NL150007

Re: Huntlee Residential Subdivision (MOD16) - Response to Engeny Peer Review

Northrop Consulting Engineers have prepared the following response to the Engeny Water Management (Engeny) peer review dated the 30 August 2021 and received from DPIE on the 23 September 2021. The following provides additional information requested by Engeny. This letter should be read in conjunction with the following documents:

FIGURE 2

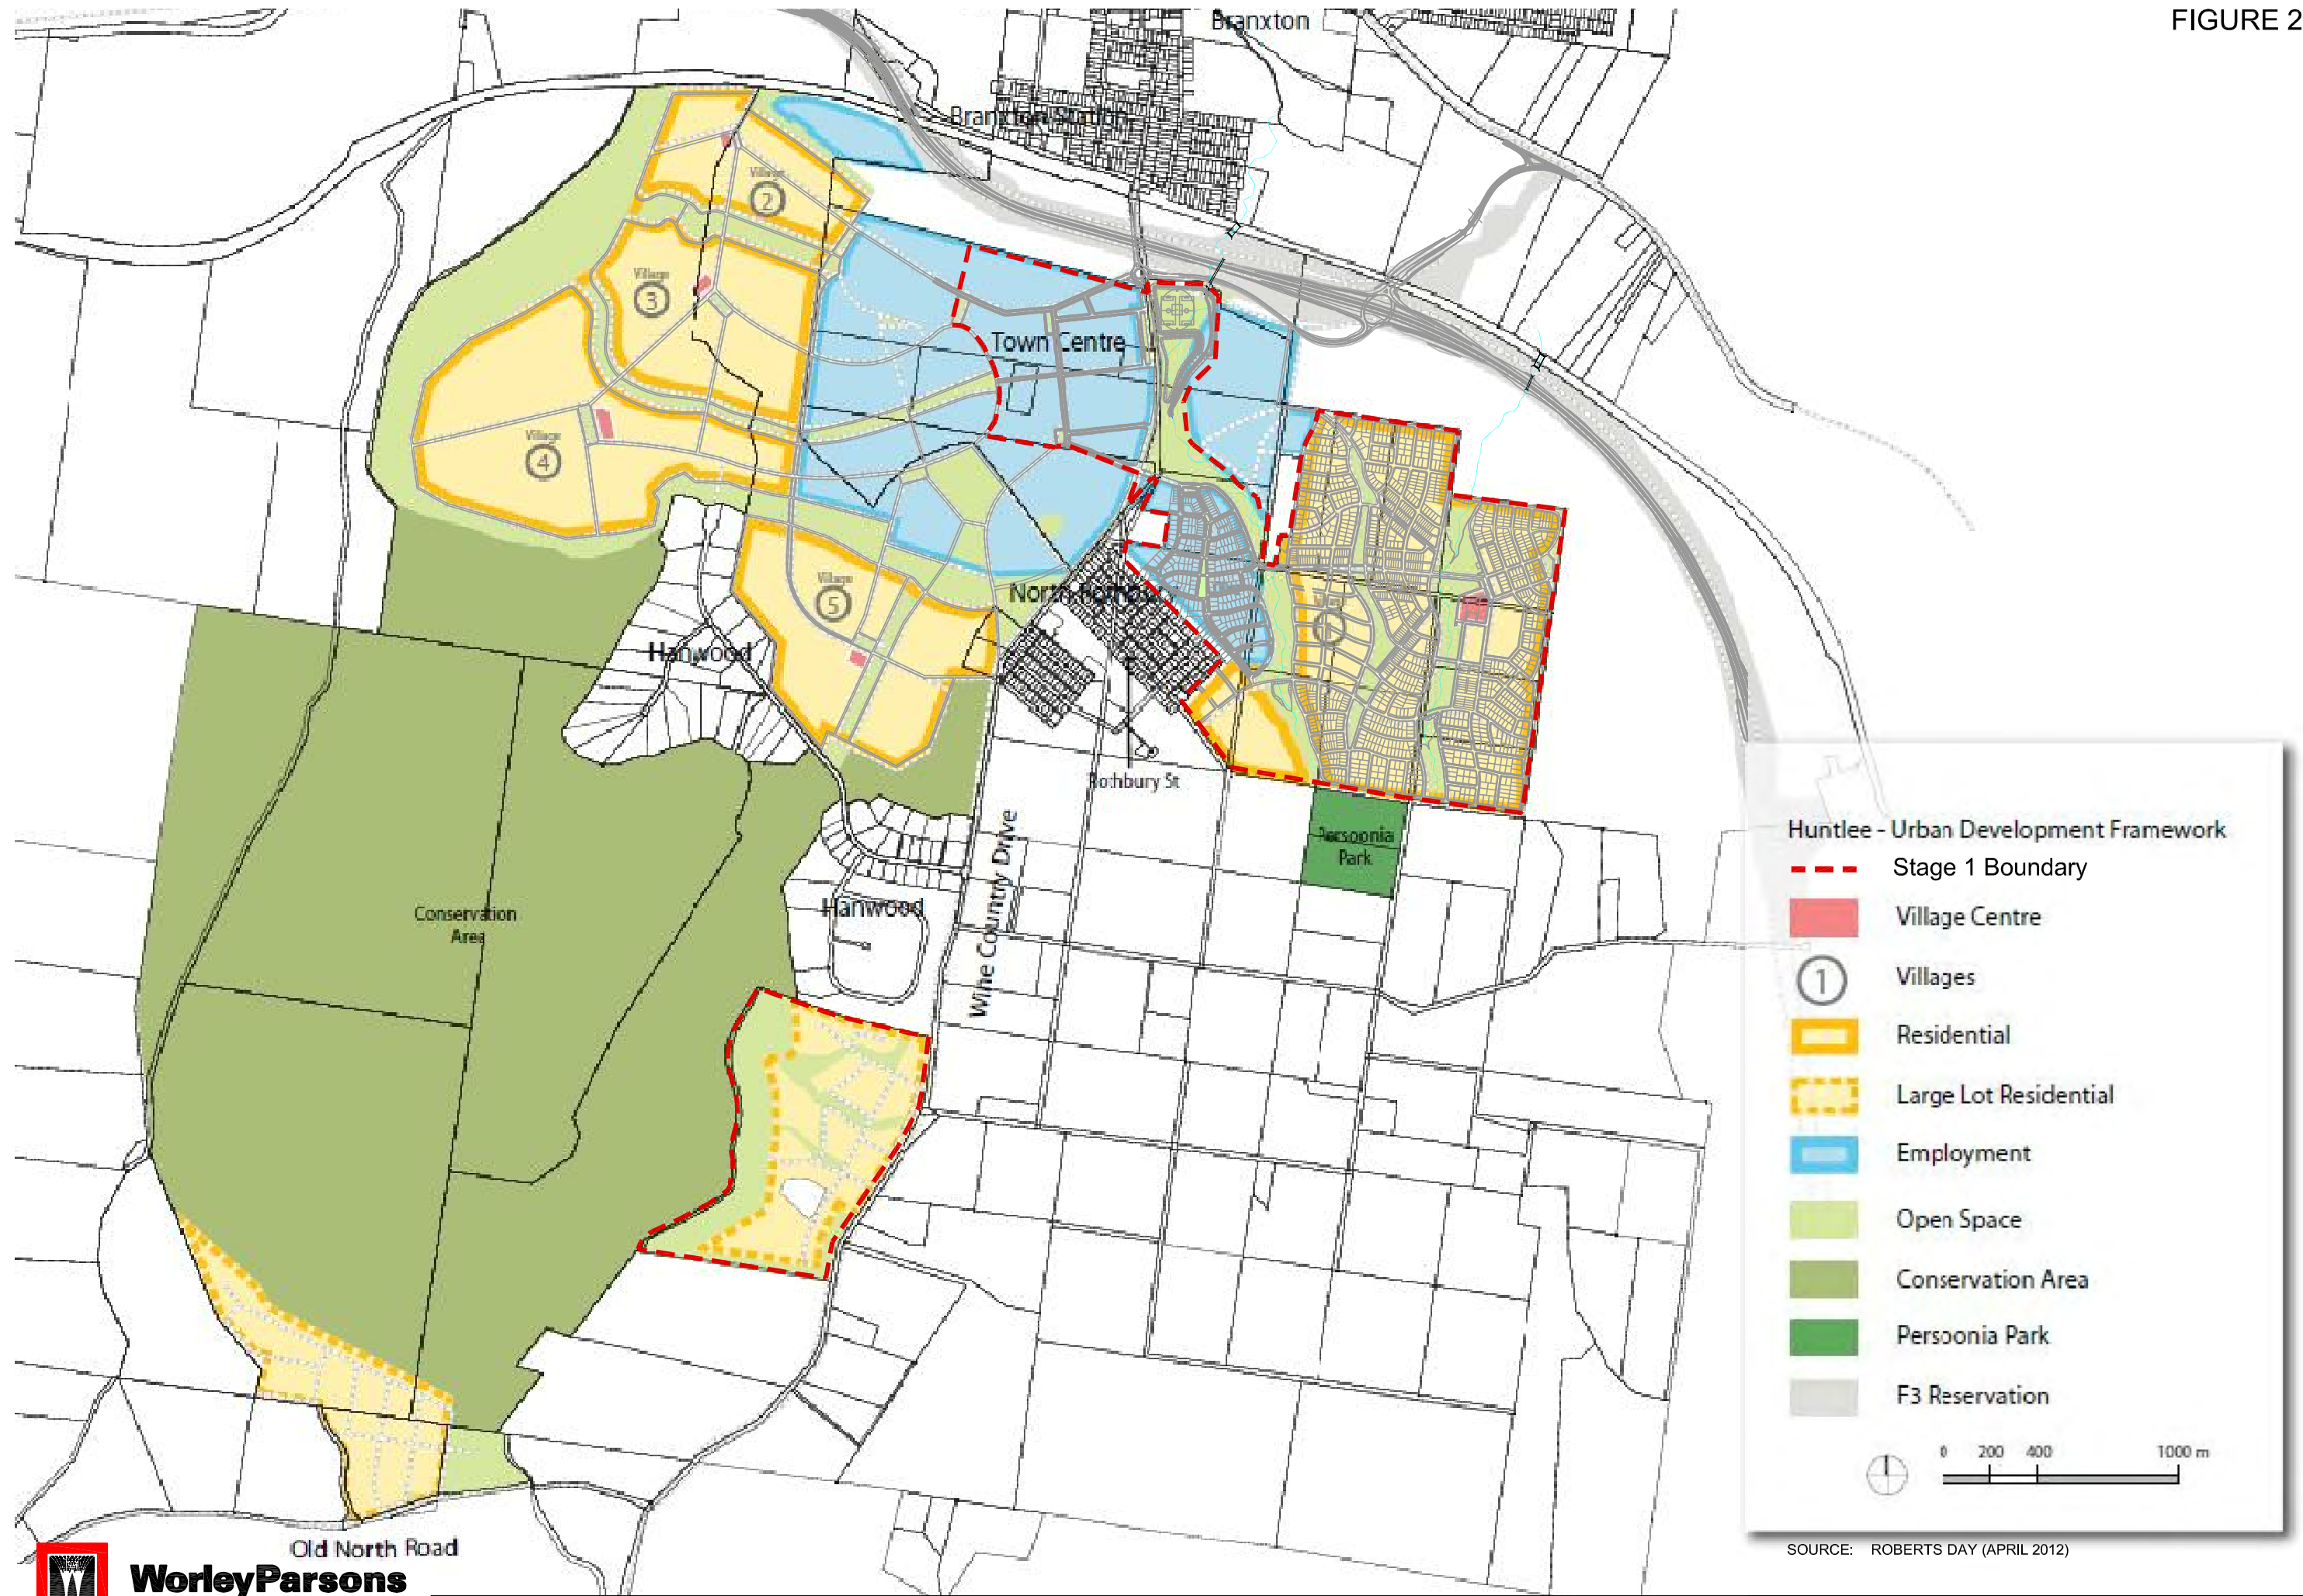
Review of Figure 3 and the tables presented in Appendix A of the Worley Study suggests there is a slight difference in the impervious percentage along the eastern side of the Tributary 1 when compared to the Northrop Study. This is due to the Primary School, Mixed Use and Village Centre land uses previously proposed.

Since the preparation of the Worley Study, the Primary School, Mixed Use and Village Centre facilities have been moved to the Town Centre, located on the western side of Tributary 2, and replaced with residential properties. As a result, the impervious percentage assumed in the Northrop Study is reflective of the currently proposed masterplan.

The Worley study assumed that the School Site would be the same percentage impervious as residential development (65% impervious). Therefore, no change to the stormwater modelling was required in the Northrop model due to the change in landuse as a result of the MOD.

Worley assumed the Village Centre and Mixed-Use zones would be 80% impervious. This has been changed to 65% impervious in the Northrop modelling to reflect the residential use. As the areas in question are very small significant changes to flows are not expected due to the change in land use.
